Please ask for: Ms Iqraa Malik
Email: iqraa.malik@terraquest.co.uk
Telephone: 01212341390
Our Ref: AW/3/21/HH
Your Ref:
Date: 12th January 2021

Application for Planning Permission for Works or Extension to a Dwelling

Development: Single storey rear extension and loft conversion with enlarged rear dormer window and two modest front facing dormer windows. Alterations to fenestration, Canopy to side elevation, Planter and replacement handrail to roof terrace.
Location: 4 Shorecroft Aldwick PO21 4AS

Drawing No. Date:
C.1062H - 04 22-12-20

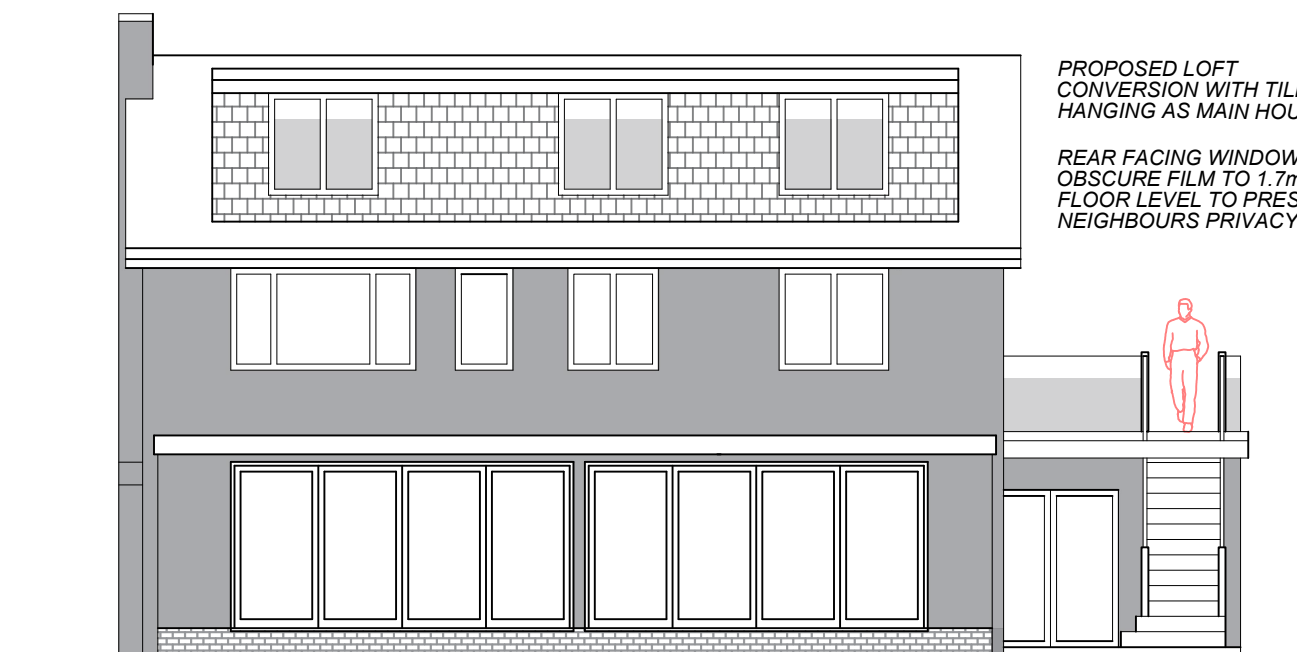
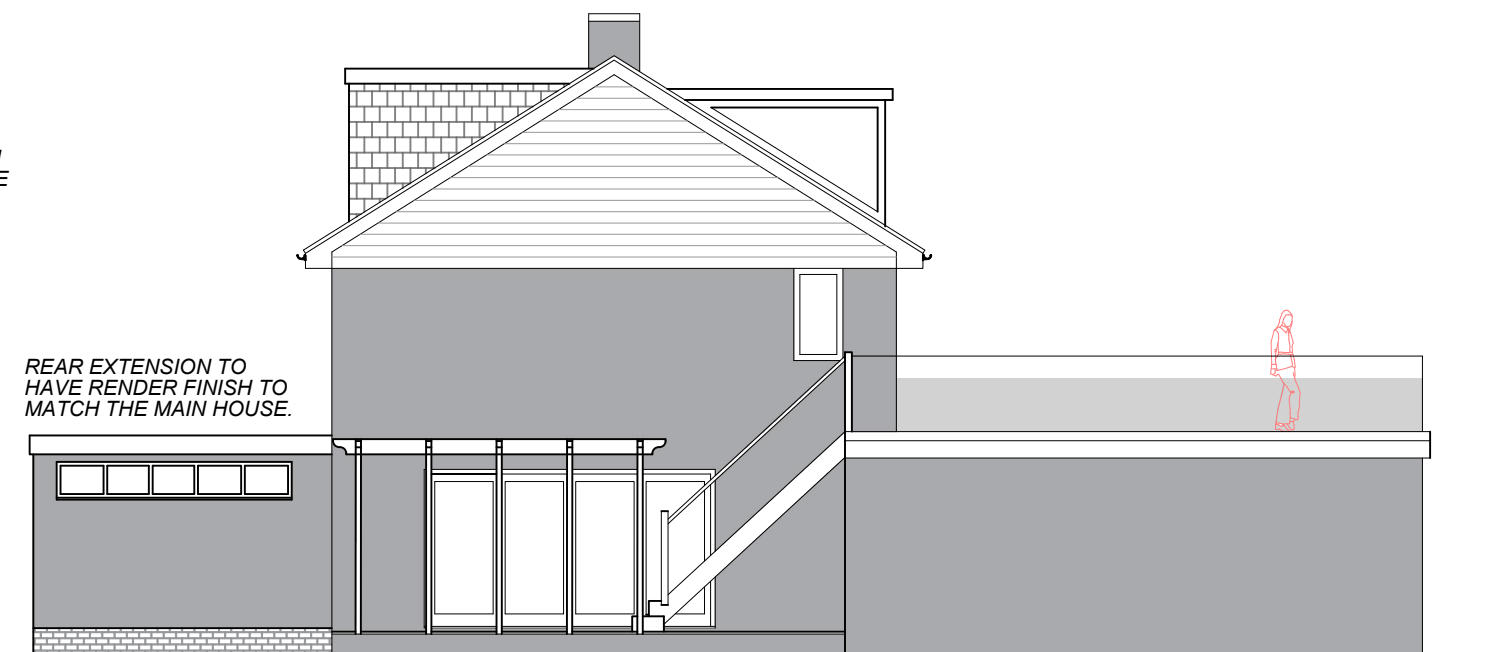
The window displayed on the east elevation isn't shown on the floor plan. Please amend.
Flood Risk Assessment
